Application for Planning Permission for Works or Extension to a Dwelling

Development: Single storey side extension with habitable roof, including front and rear dormers, following demolition of existing outbuildings. Resubmission of approved scheme BE/12/26/HH with revised Ownership certificate
Location: 99 North Bersted Street Bersted PO22 9AF

Side Elevation - East

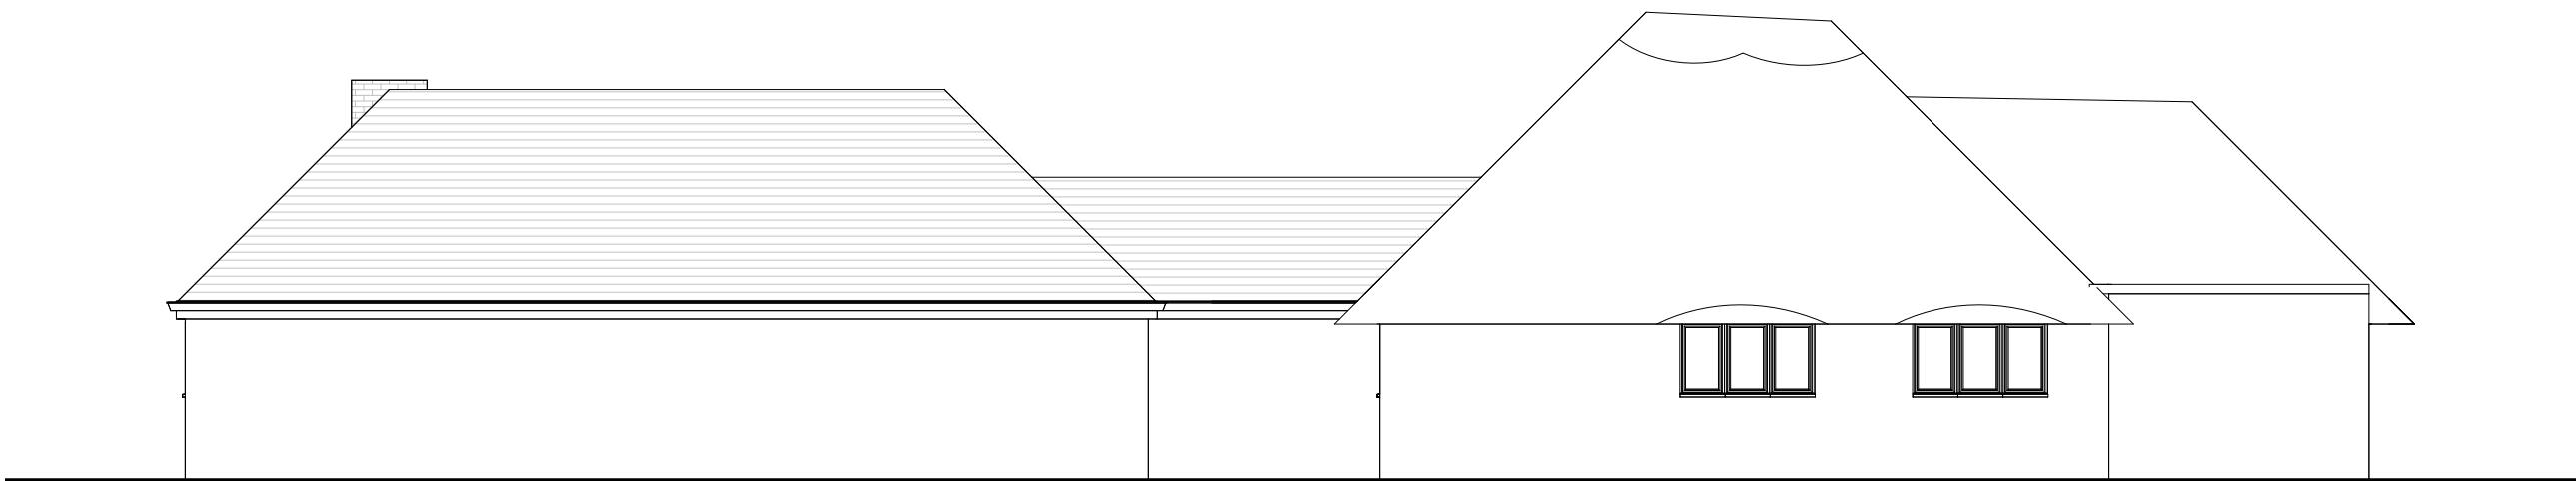
The existing east elevation plan needs to show the main dwelling fully.

Site Plan 1:500
Site Plan 1:1250

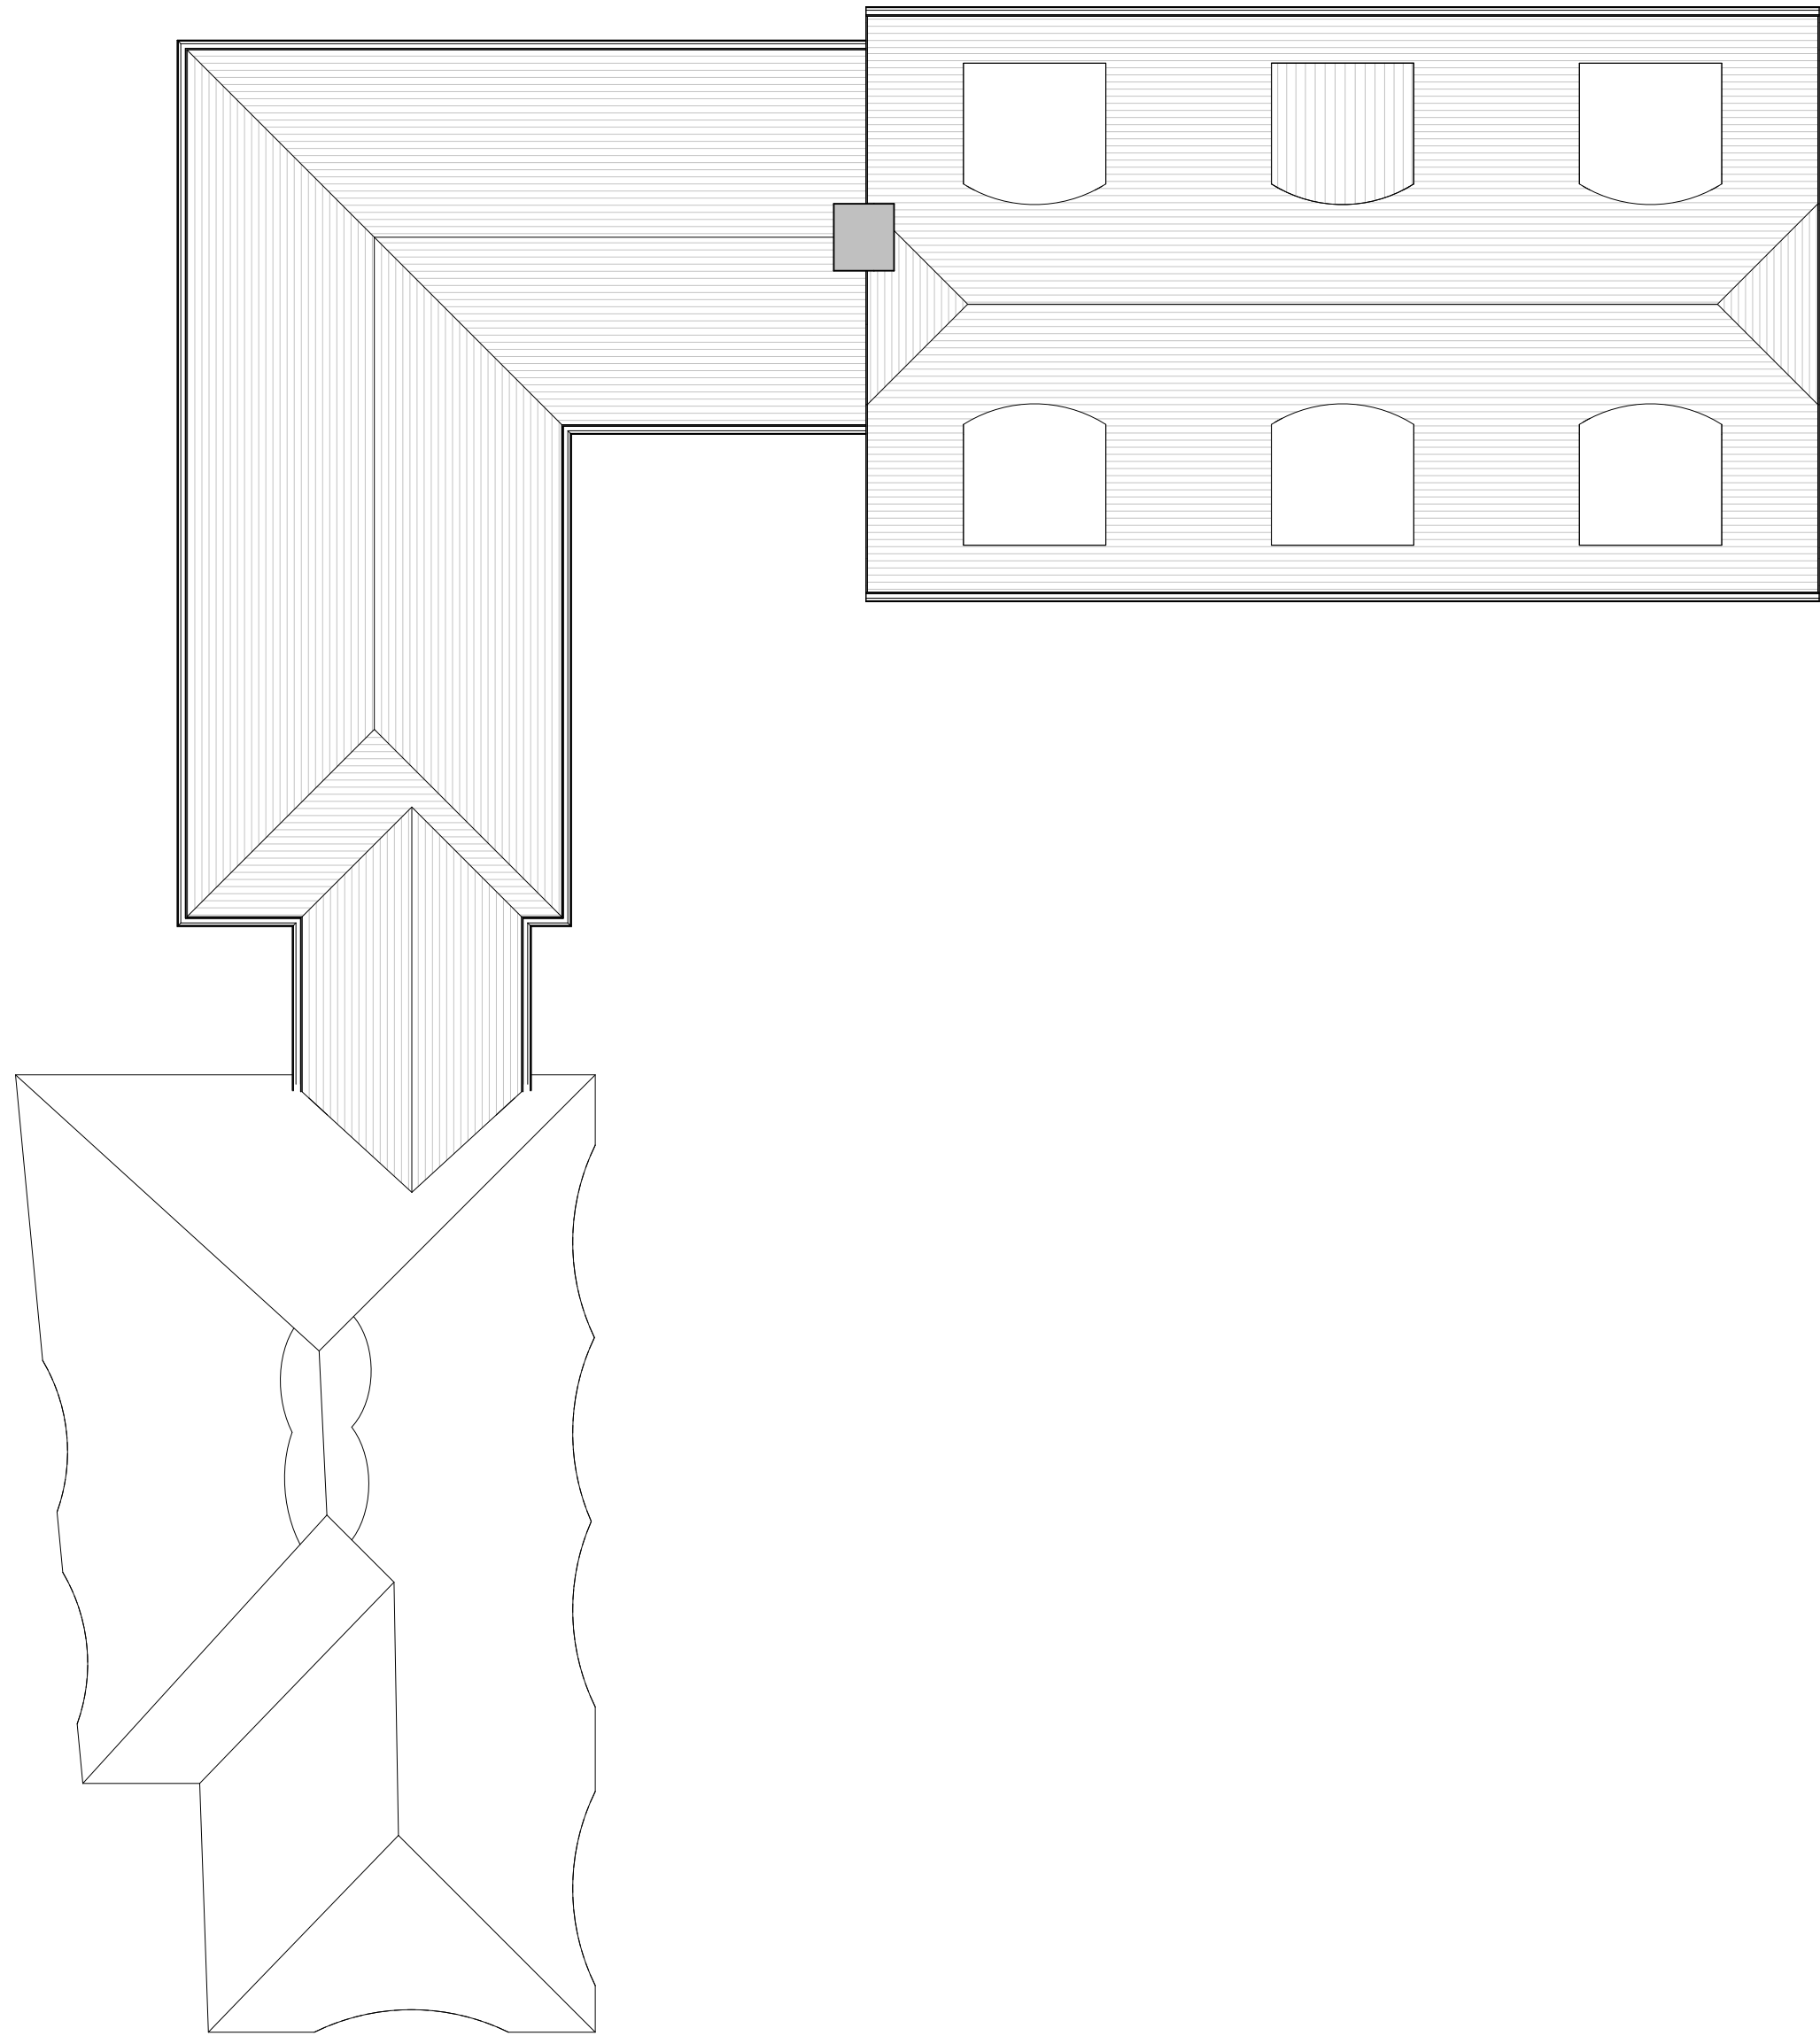
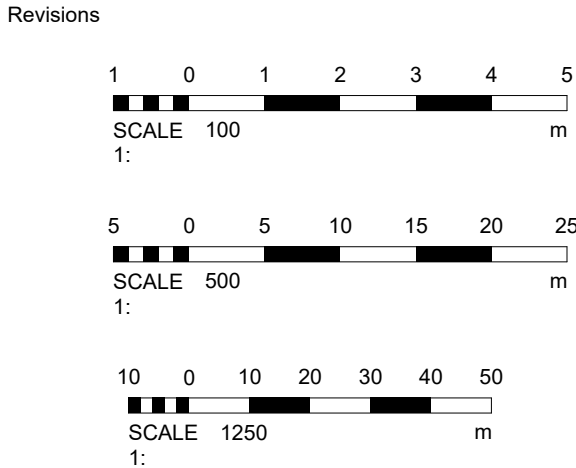
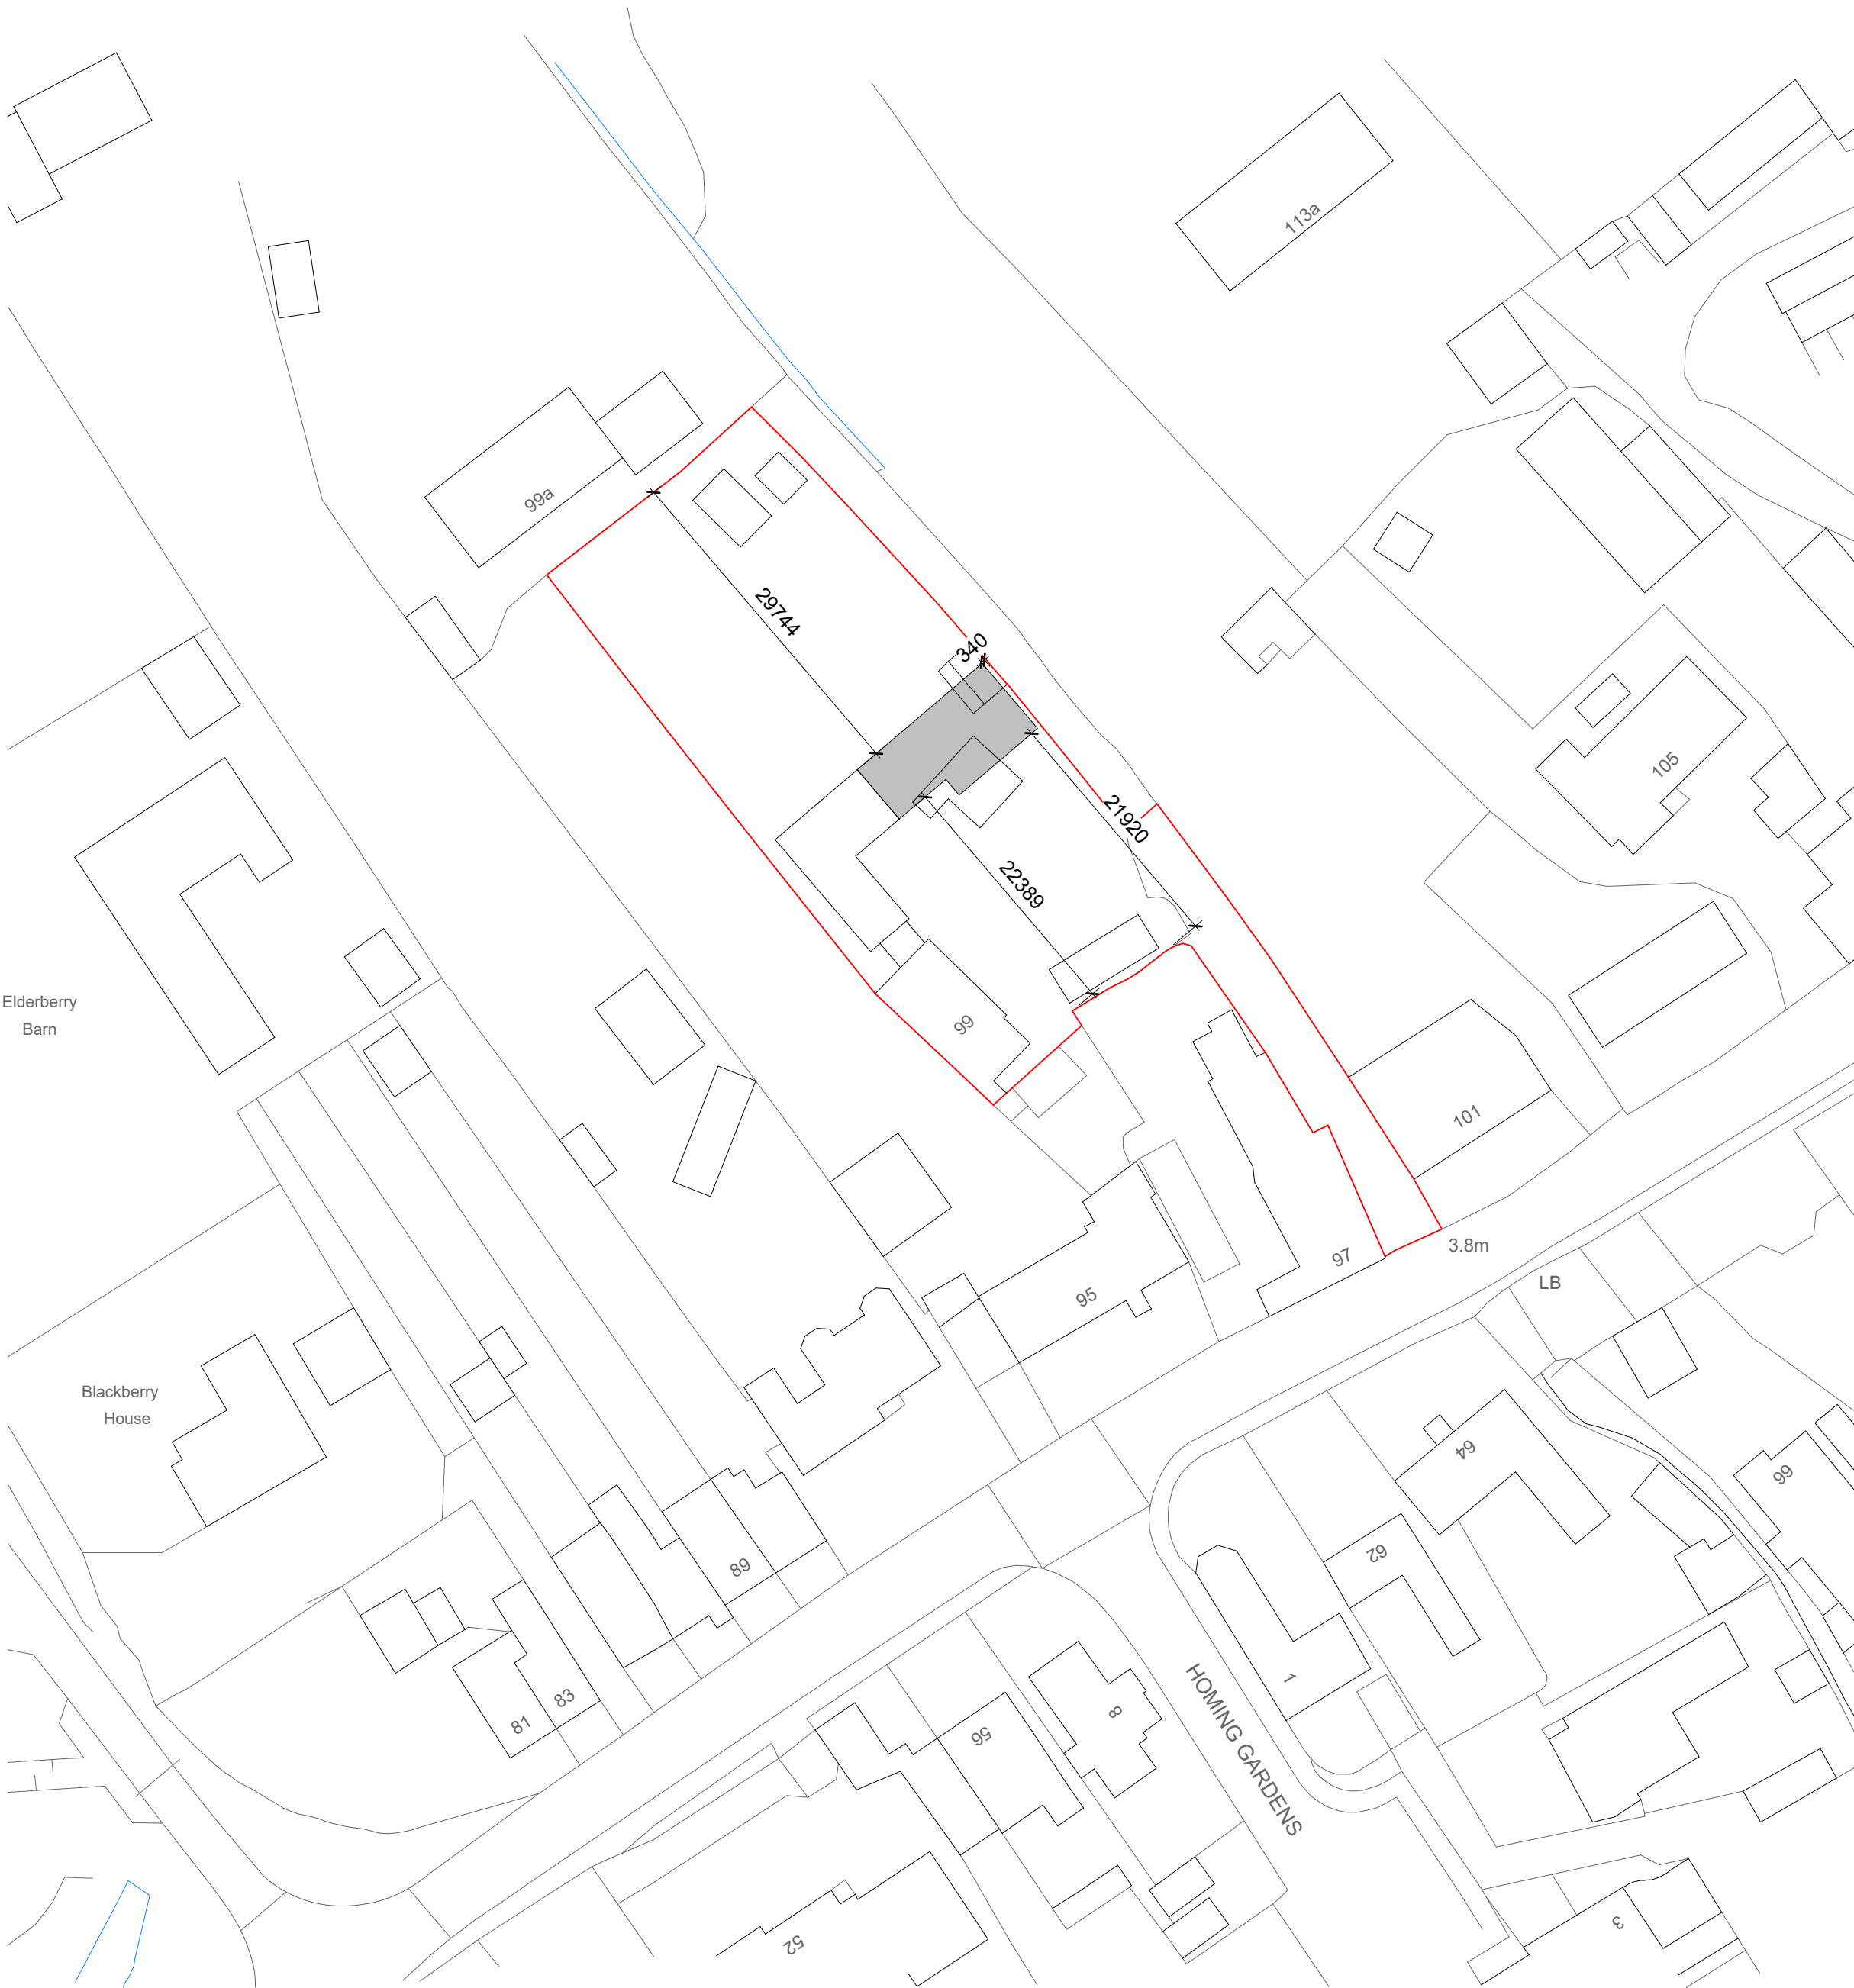
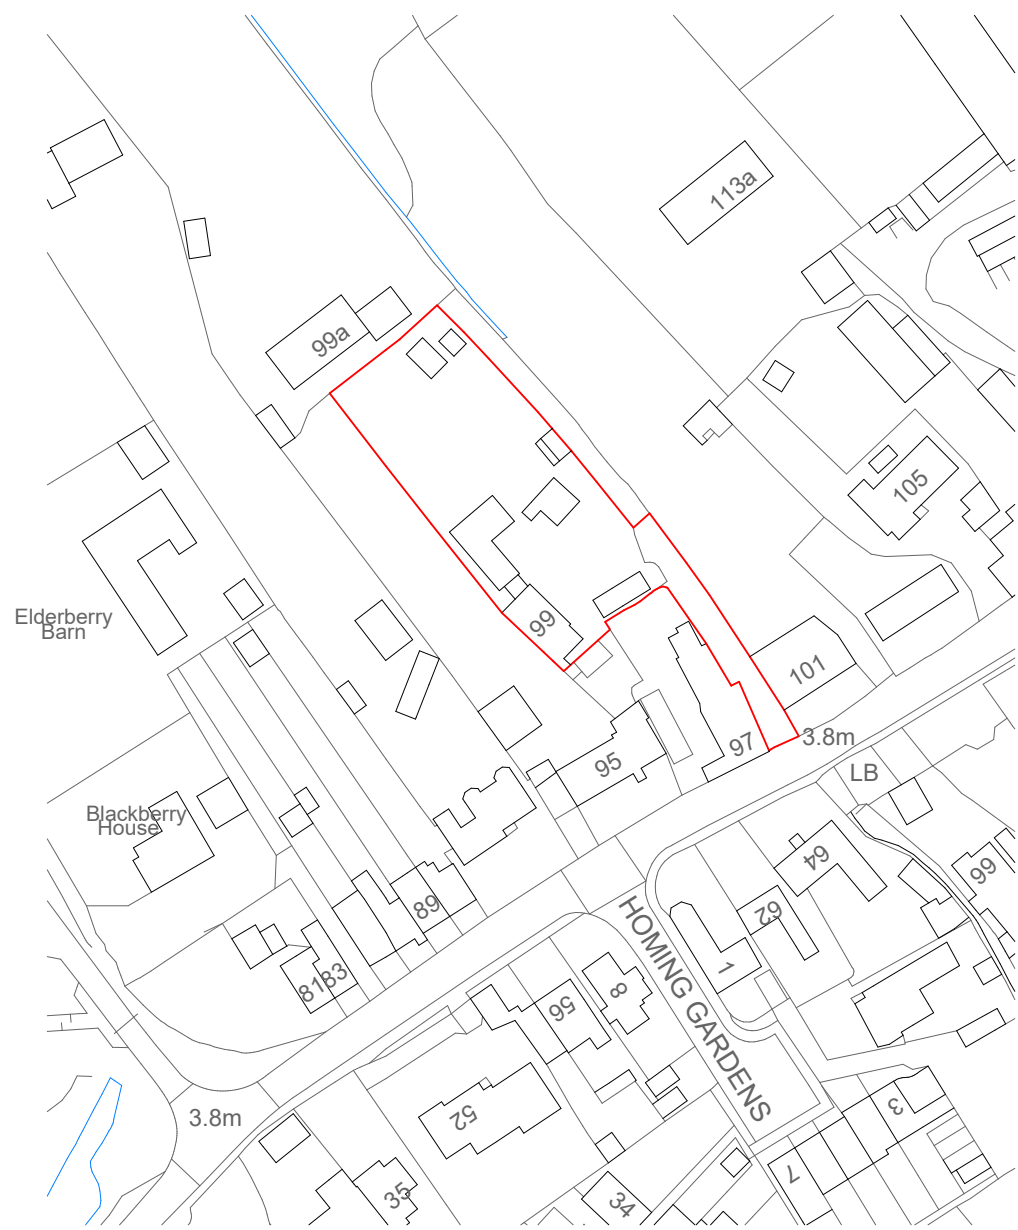
The location plan should be existing and not have the proposed works drawn on it.

The 1:500 block/site plan is the plan which needs to show the extension and dimensions to site boundary.
